DRB Application No.: 09ARB-70534 Project # 1003565  
 Project Name: MIRAMONTES PARK UNIT  
 Agent: JOSH SHARSGARD Phone No.:

**DRB CASE NO/PROJECT NO: 1003565**

DRB CASE NO: 1003565

FINAL PLAT  
PRELIMINARY PLAT  
SITE PLAN FOR SUBDIVISION

# SITE PLAN FOR SUBDIVISION LOTS 1-A BLOCK 8 MIRAMONTES PARK, UNIT 1

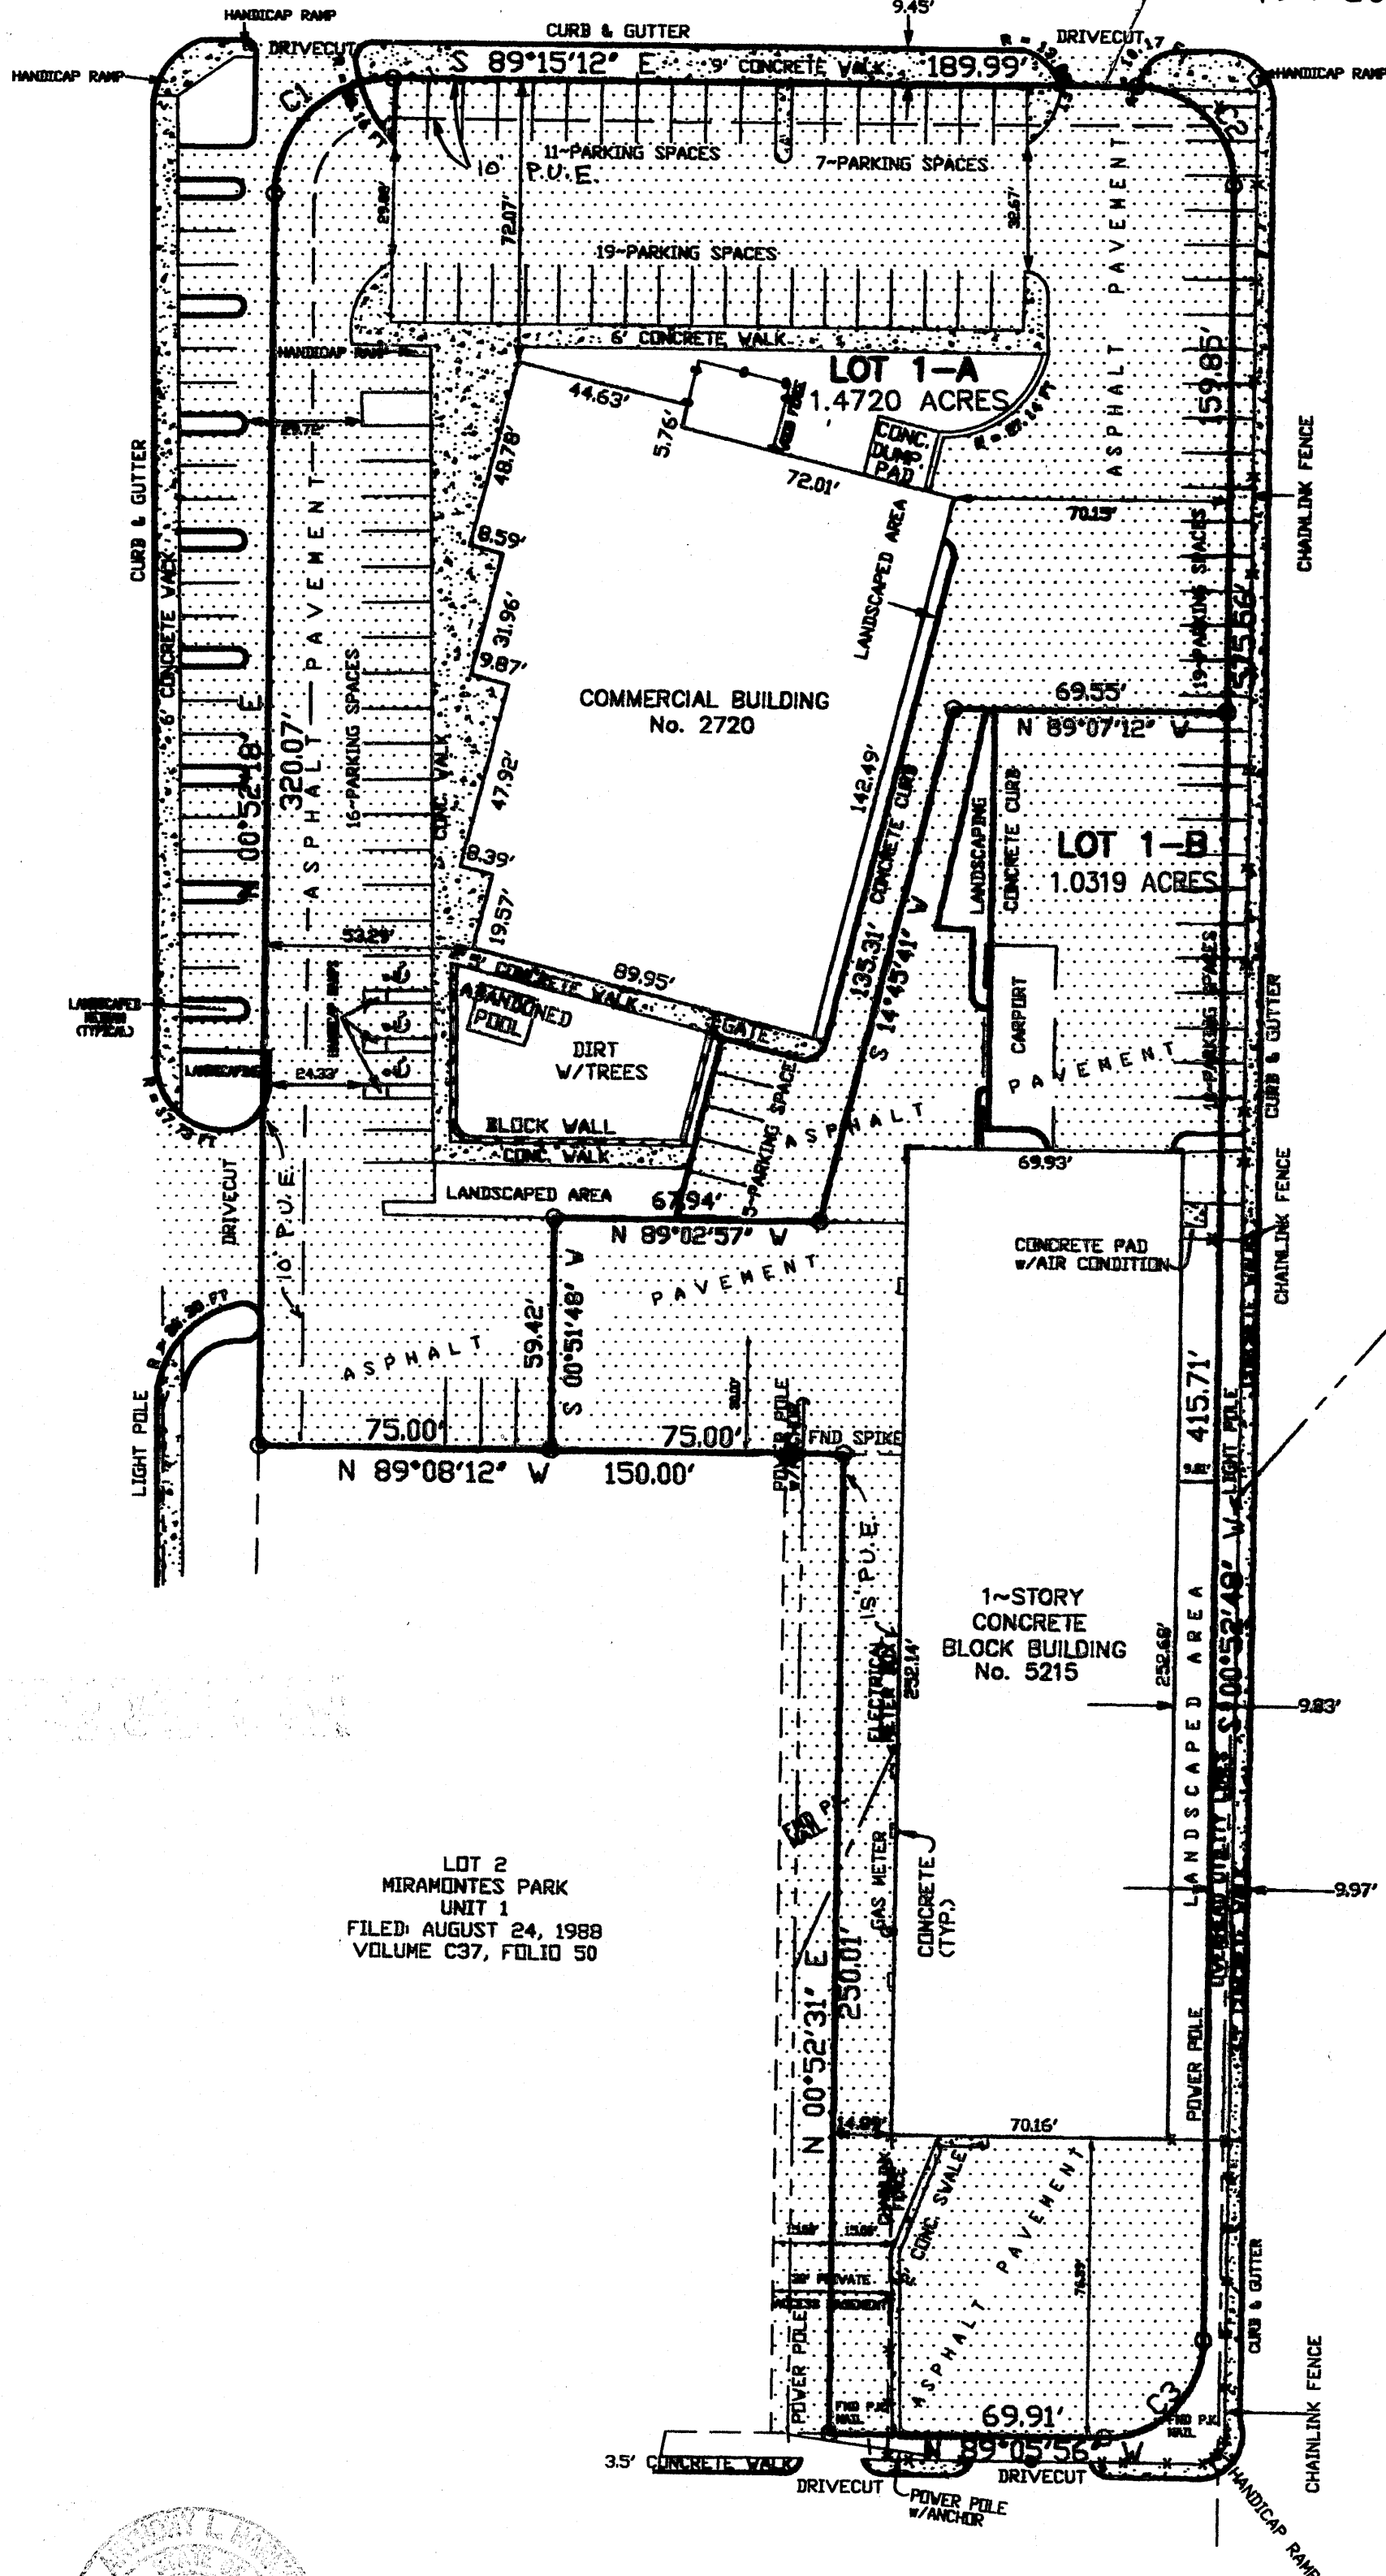
Provide an exhibit showing the location of sidewalk and defining the distance from face of curb to the property line. Right of way dedication may be required.

A cross access easement is needed between lots 1-A and 1-B.

The site plan application is for site plan for subdivision, not building permit. Please change the title block of your site plan accordingly.

The parking spaces adjacent to San Mateo Blvd. are located within the right of way. A revocable permit will be required for these parking spaces (contact Jane Rael, 924-3992).

Widen the existing easternmost curb cut along Claremont Avenue to 24 feet wide. The existing westernmost curb cut along Claremont Avenue may remain in place.

**PLAT OF
LOTS 1-A AND 1-B
BLOCK 8
MIRAMONTES PARK, UNIT 1**

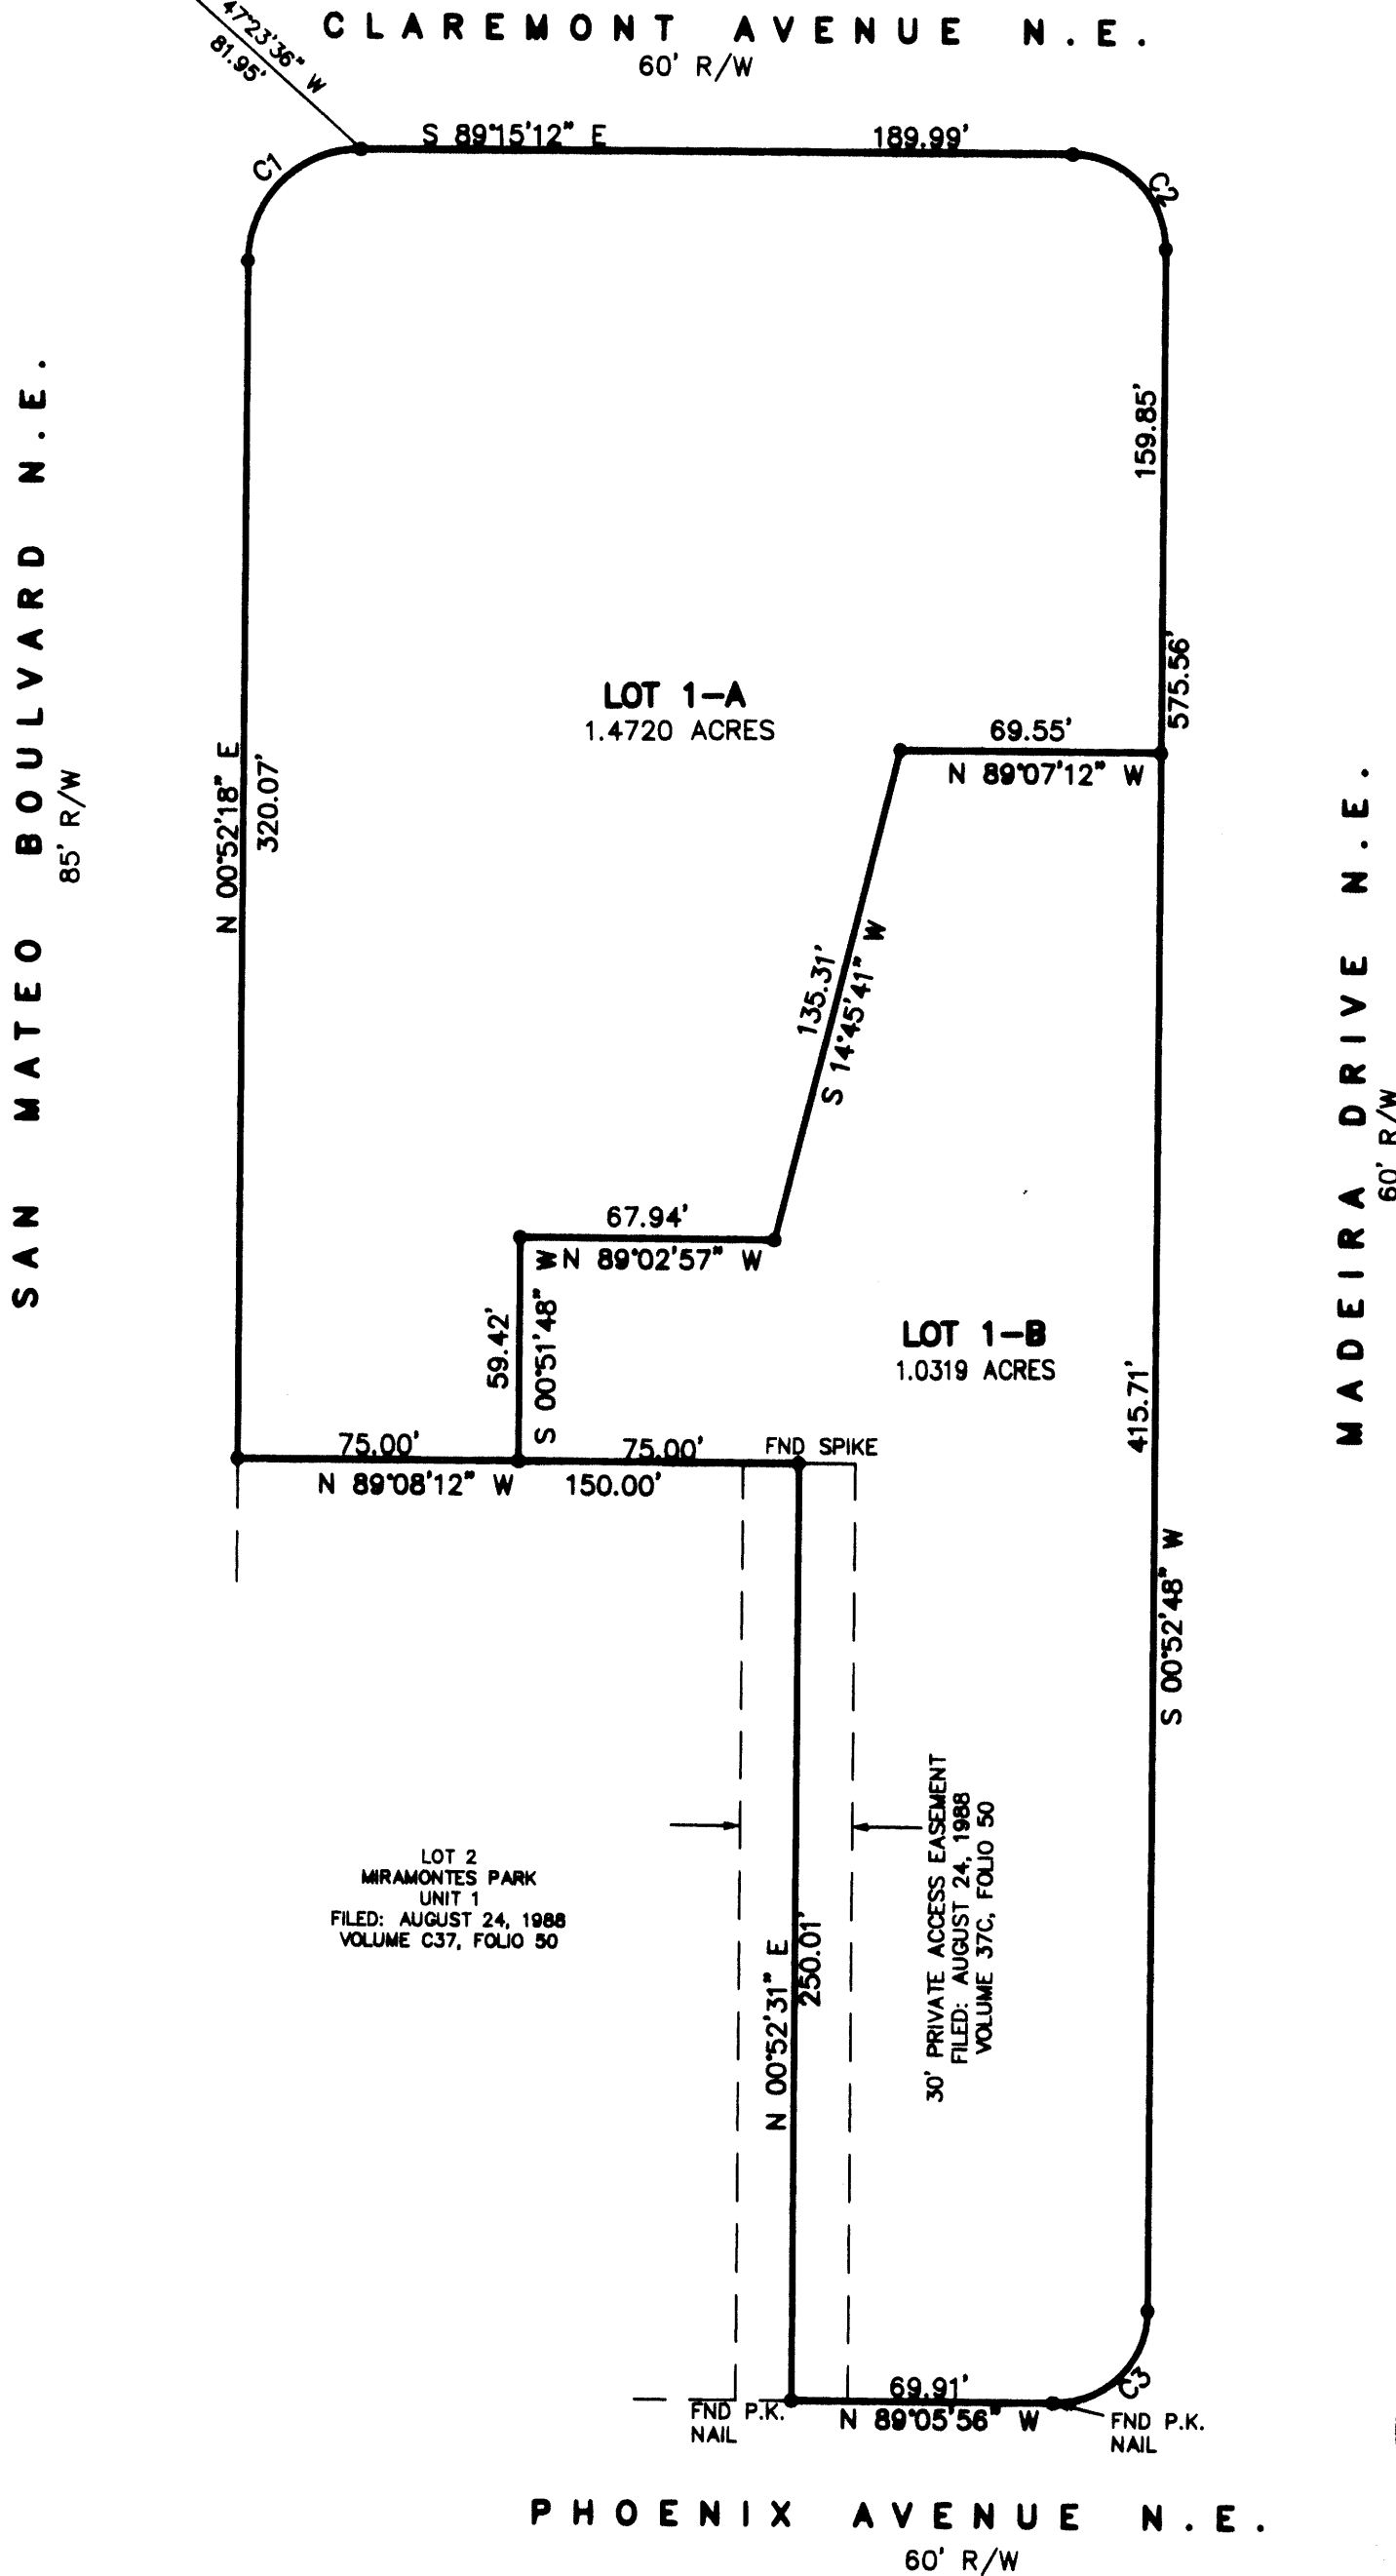
TRANSPORTATION: - exhibit; Reciprocal Easements;  
Solar Note; Utility Co signatures

UTILITIES: - meter set, sewer agreement
